CHENNAI METROPOLITAN DEVELOPMENT AUTHORITY
Thalamuthu Natarajan Building, No.1, Gandhi Irwin Road, Egmore,
Chennai - 600 008
Phone : 28414855 Fax: 91-044-28548416
E-mail: mcmda@tn.gov.in
Web site: www.cmdachennai.gov.in

Letter No. C3(N)/19019/2016, dated .04.2017

Sub: CMDA – APU – MSB (North) Division – Planning Permission Application for the proposed construction of Multi-storied Group Development building consisting of 2 Blocks commercial cum residential use, at Block No. 1 - G.Floor + 1st Floor + 2nd Floor (Commercial use) + Service Floor and 3rd Floor to 12th Floor (Residential use with 60 dwelling units) and Block (Amenity Block) No. 2 - Stilt Floor + 4Floors (Stilt + 1st & 2nd Floor for Puzzle Parking up to 8.40 m height accommodating 17 Nos of car parking and Gym & Multipurpose Hall at 3rd & 4th Floor) at rear side. In survey No. 219/ 2A, 2B1B & 24 of Kattupakkam Village, Poonamallee High road, Chennai, within the limits of Poonamallee Panchayat union - Applied by **M/S. Pooja Foundation Pvt Ltd (Rep. by its Director B. Budhmal Bohra) & Others, (GPA Holder)** - Proposal placed before the MSB Panel - Recommended and forwarded to Government for Approval –Reg.

DRAWING TITLE
SITE CUM GROUND FLOOR CUM STILT FLOOR PLAN

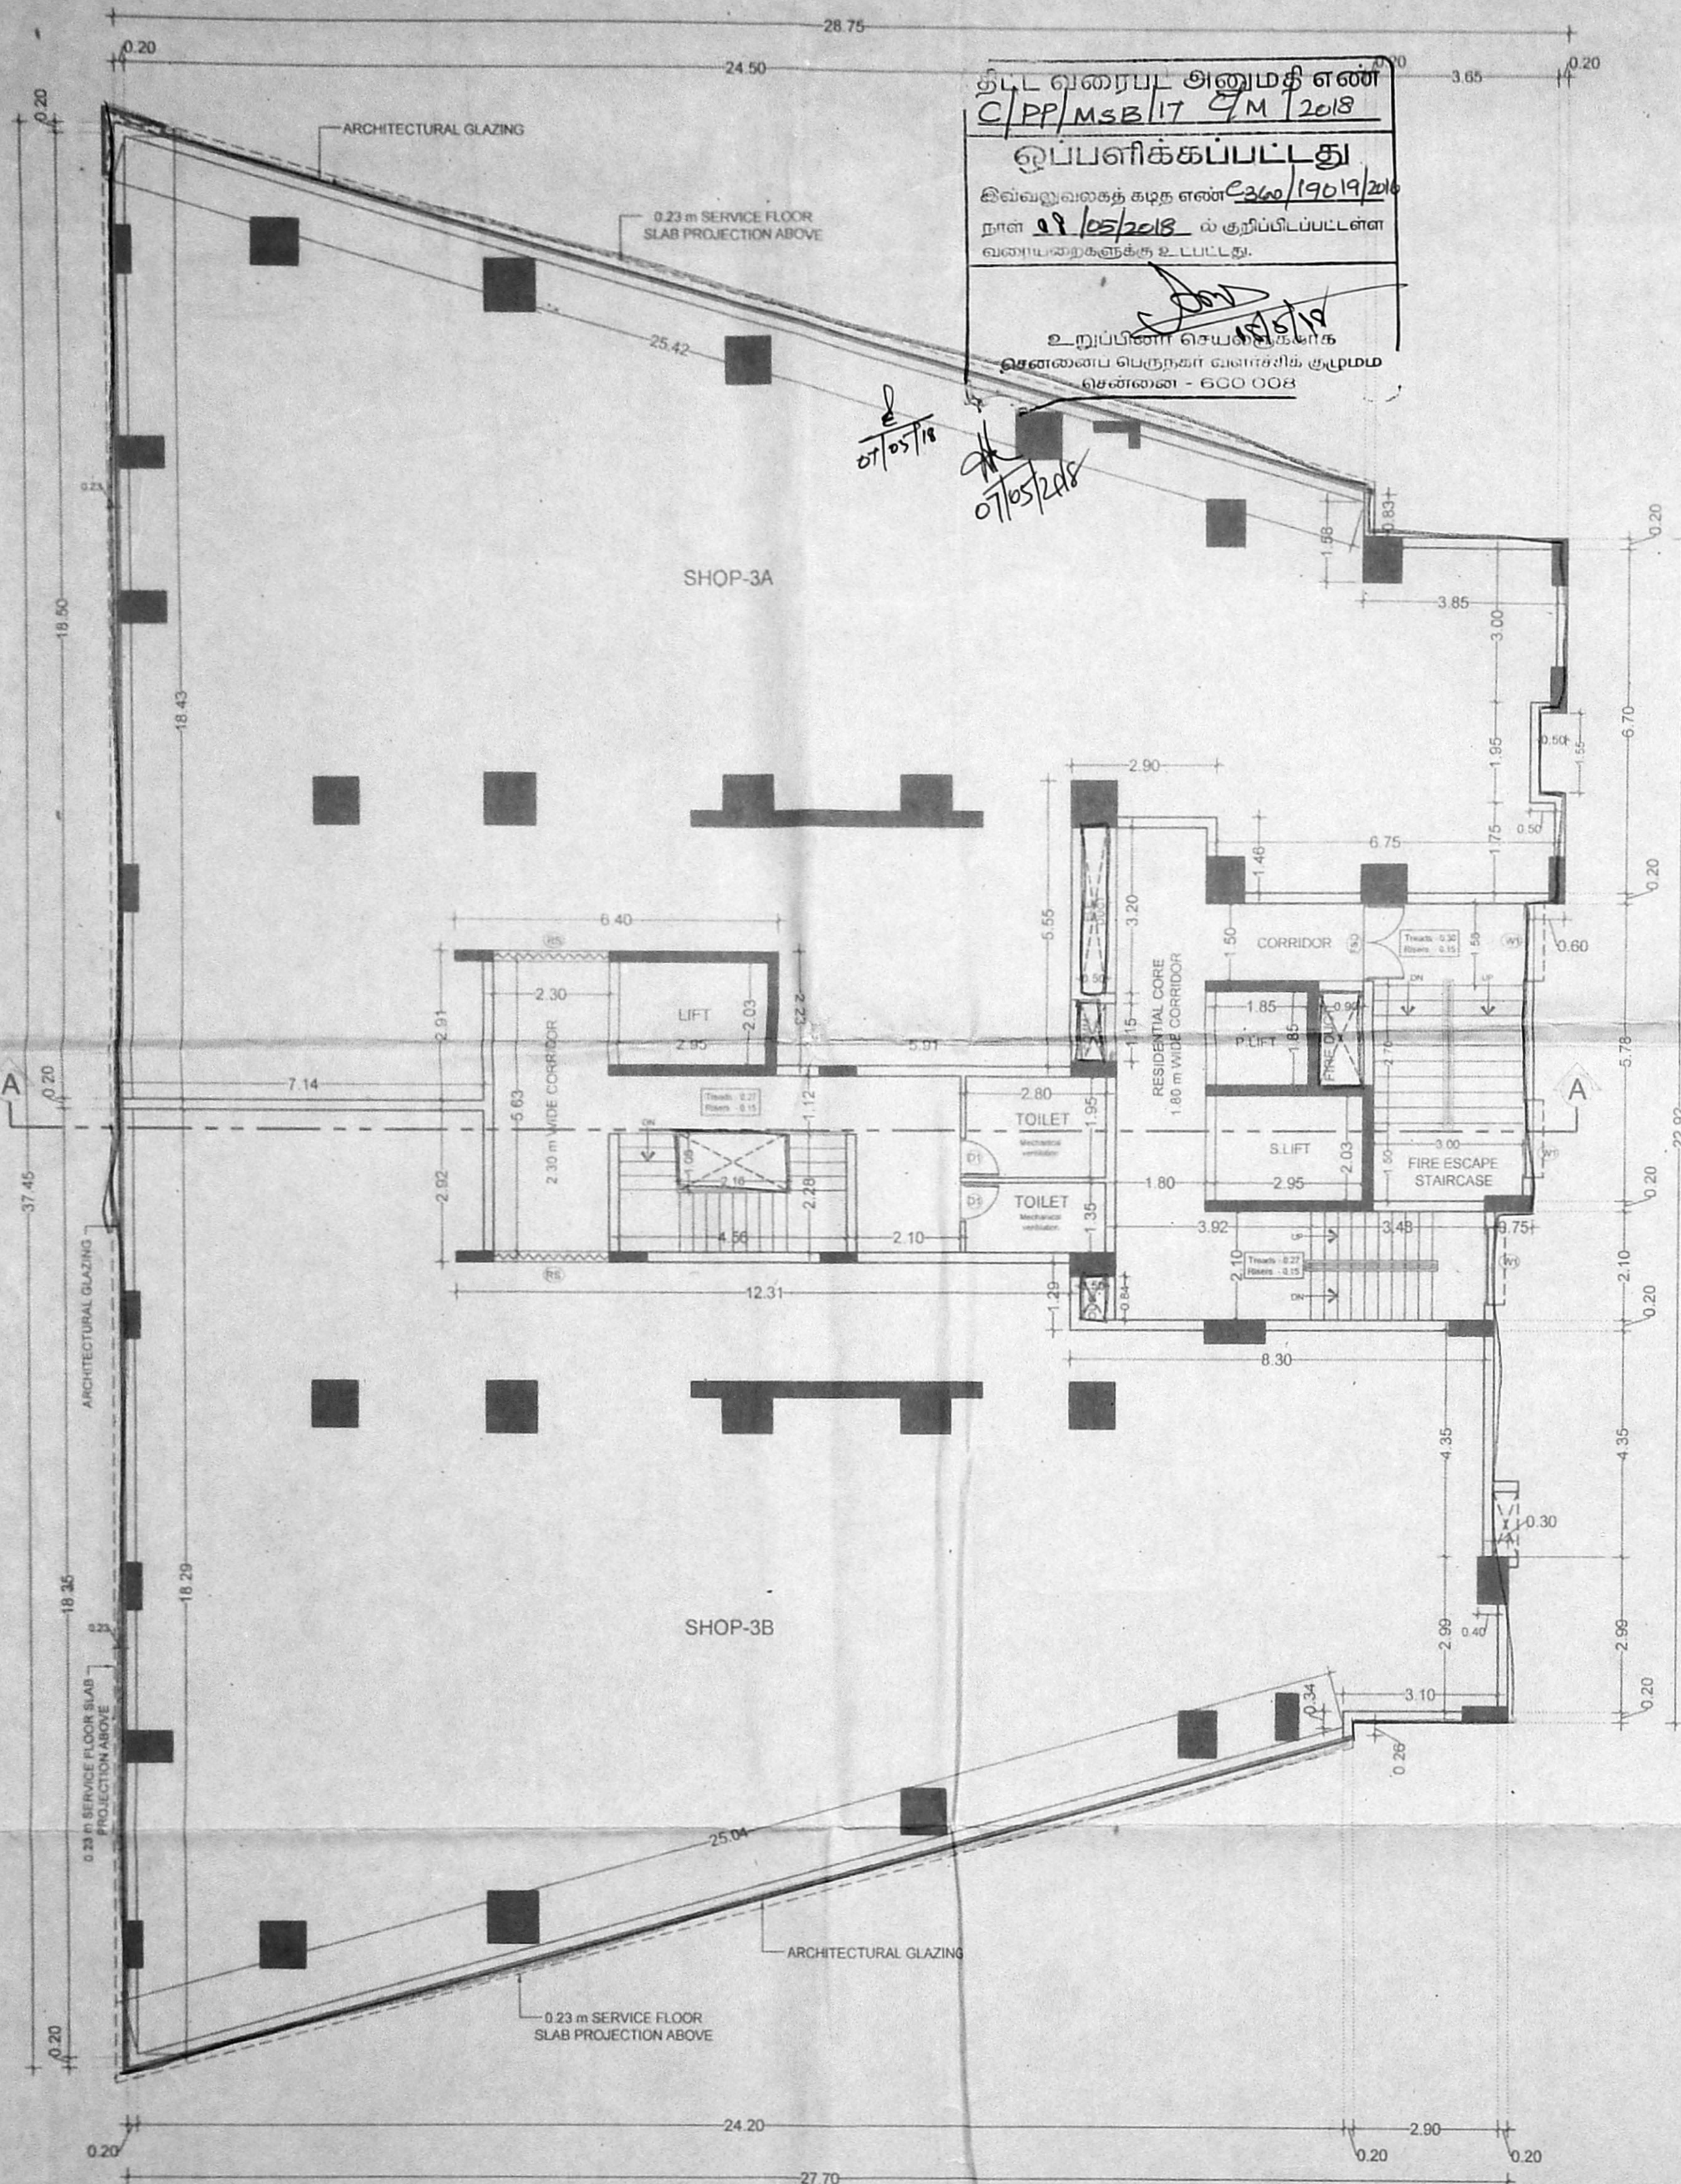
- (vi) Specific remarks to be obtained from the DF&RS on the access to the Snorkel from the road and any hazardous to the occupants due to the proximity of the H.T.Tower line existing in the site before issue of DC advice.

3. The proposed 5 nos of PH car parking are undersized.
4. Overall site measurement shown in the FMB & in the plan not tallies and in the FMB boundary measurements are not clear.

5. Site plan as per FMB & Site to be shown properly excess land to be differentiated by hatching and setbacks to be shown from the linear site boundary & it is from perpendicular to site boundary.

6. In stilt floor entry/exist to the puzzle parking to be shown properly.
7. Existing H.T. Line alignment as per the site conditions to be marked in the FMB duly signed by the revenue official not below the rank of deputy tahsildar to be furnished. Accordingly the H.T.Line to be shown in the site plan.

8. Existing L.T.Line to be shifted in this regard a letter obtained from TNEB to be furnished stating that the L.T Line will be shifted.
9. Setbacks to be shown properly in the Site plan. Also to be Tallied with APPAS Drawing and Distance between blocks also to be shown properly.

10. Detail drawing for sump for sullage, Fire & RWH to be shown.
11. Location of STP in the site plan & detail drawing as per NOC obtained from CMWSSB to be furnished.

12. In the key plan proposed site u/r access from 2 roads to be shown properly.
13. In the site plan abutting road name to be mentioned and another road on south also to be shown with name and width of the both as per site to be shown.

DRAWING TITLE:
**BLOCK - 1 :
3RD FLOOR PLAN & 4TH FLOOR PLAN**

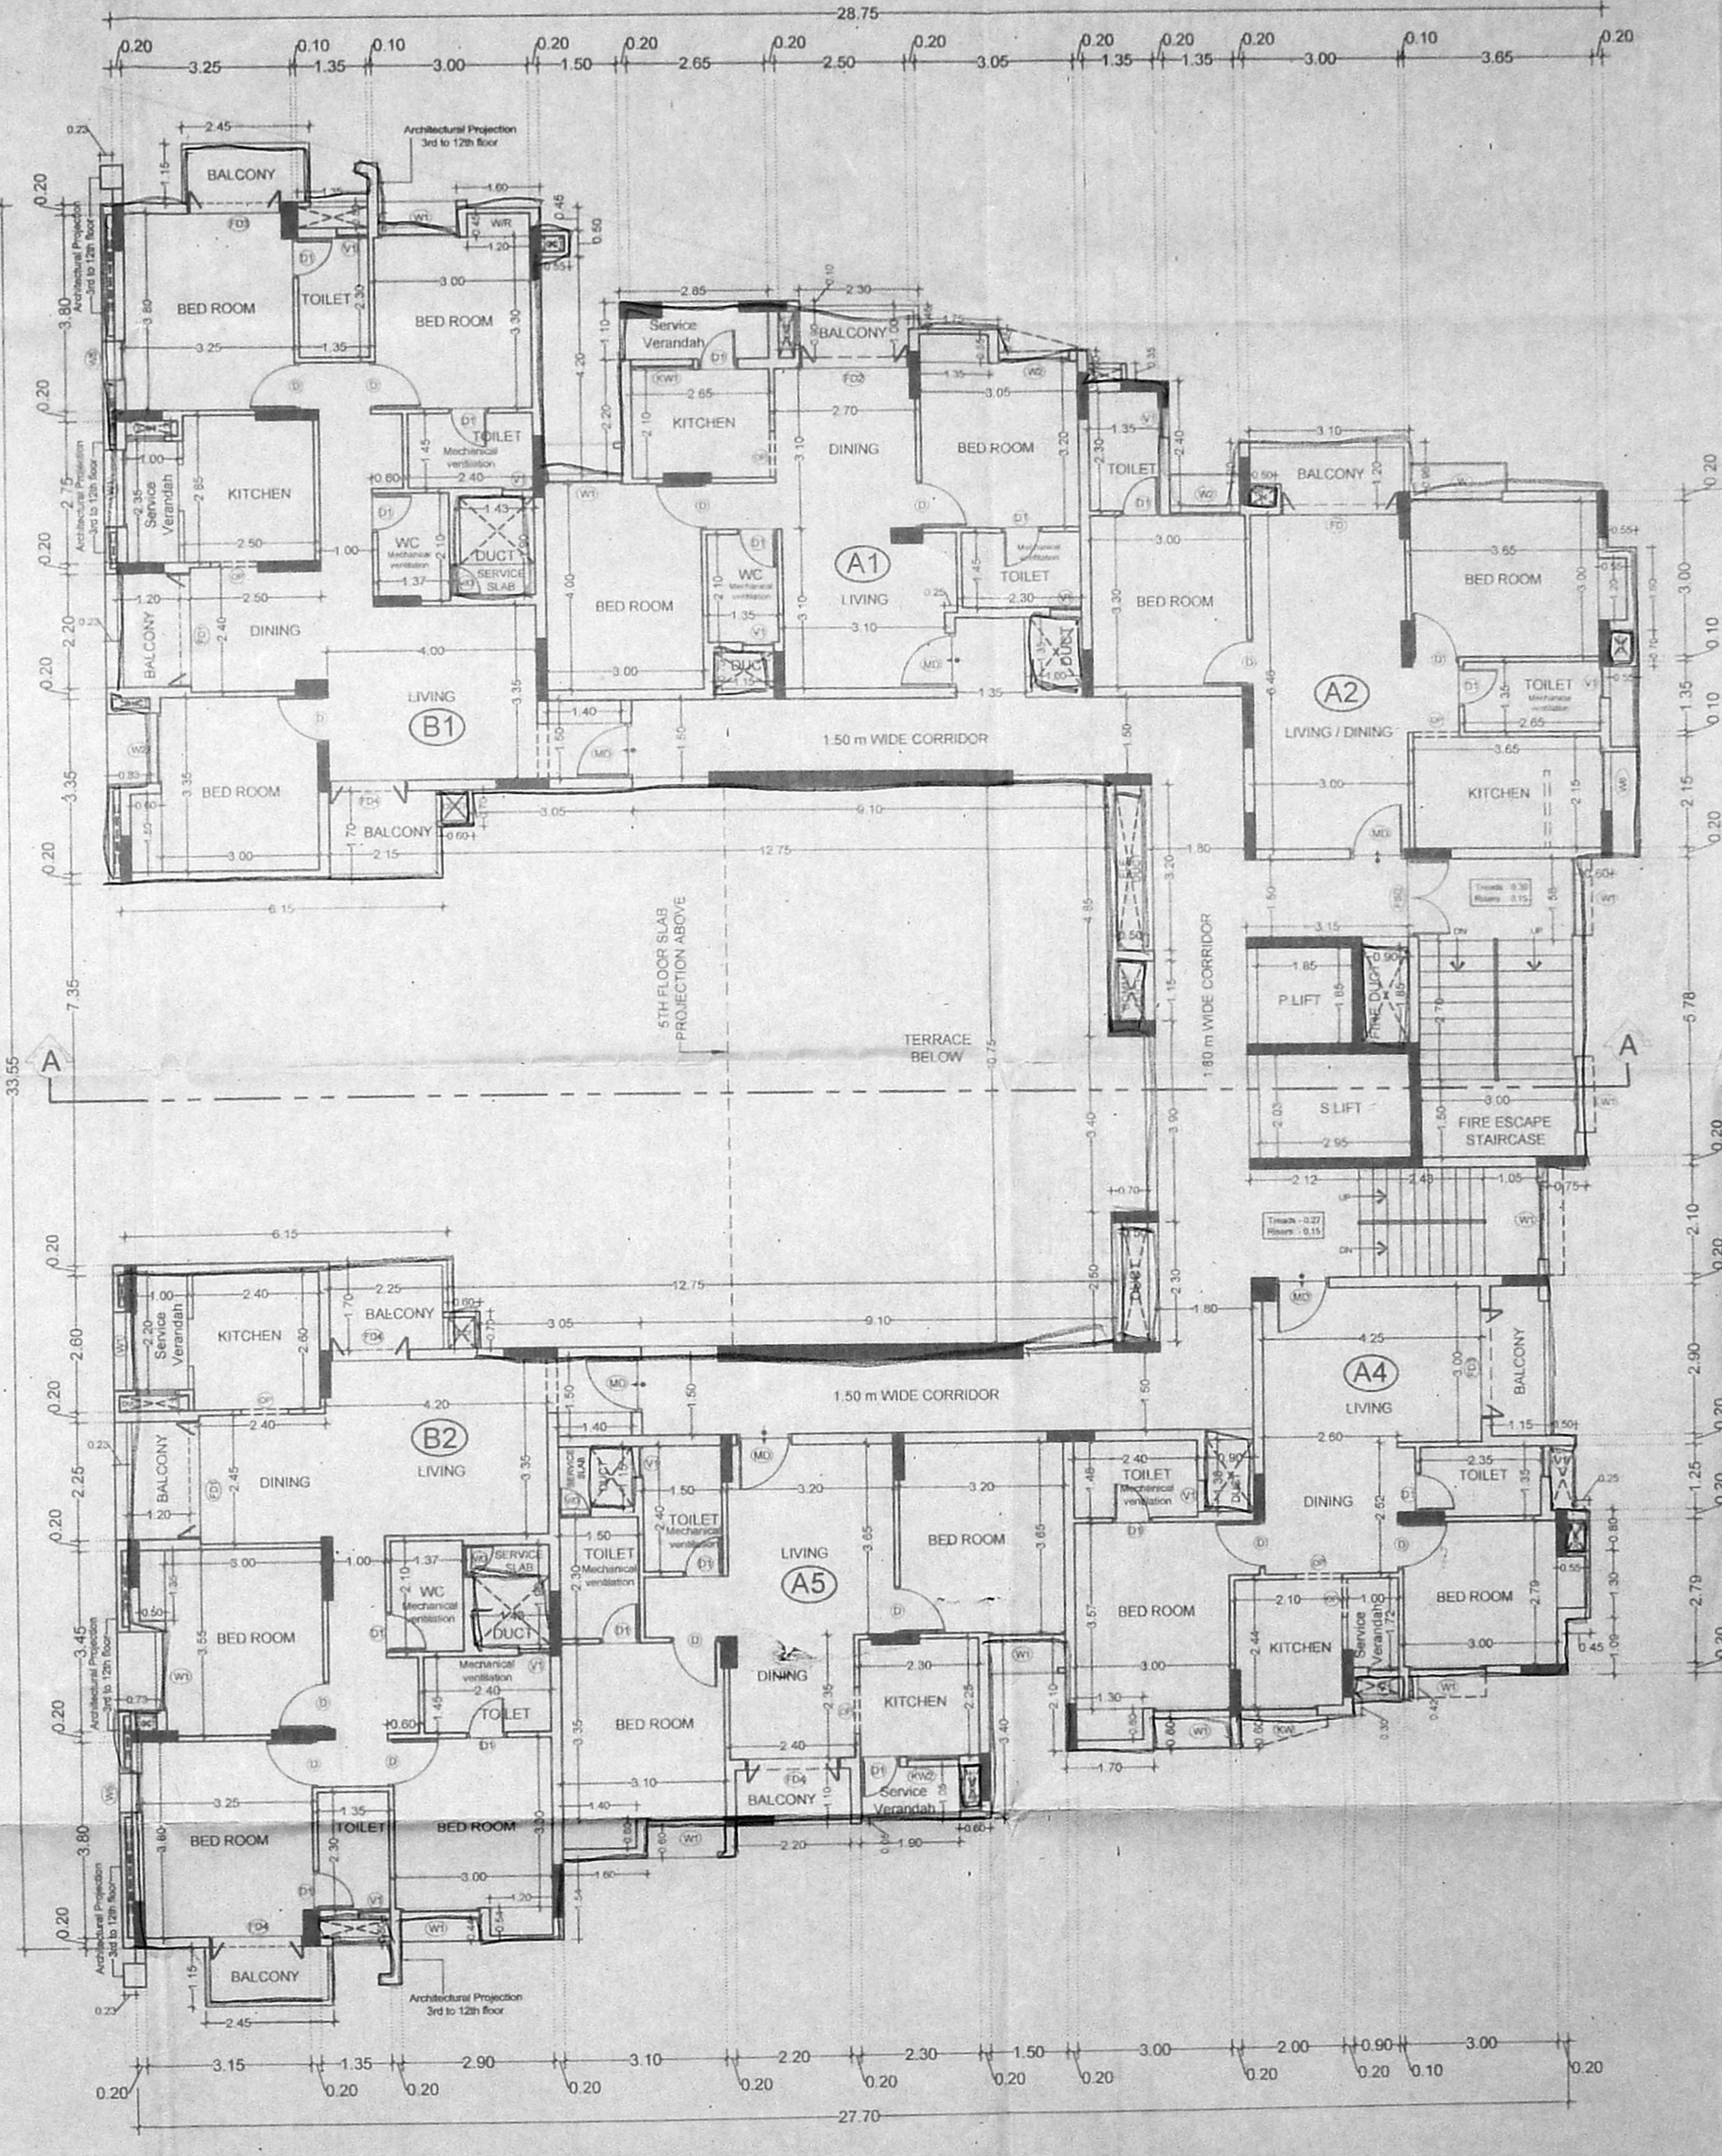
17. 3rd floor roof projection above to be shown and 4th floor roof projection above to be indicsted & low terrace area at 4th floor plan also to be shown.
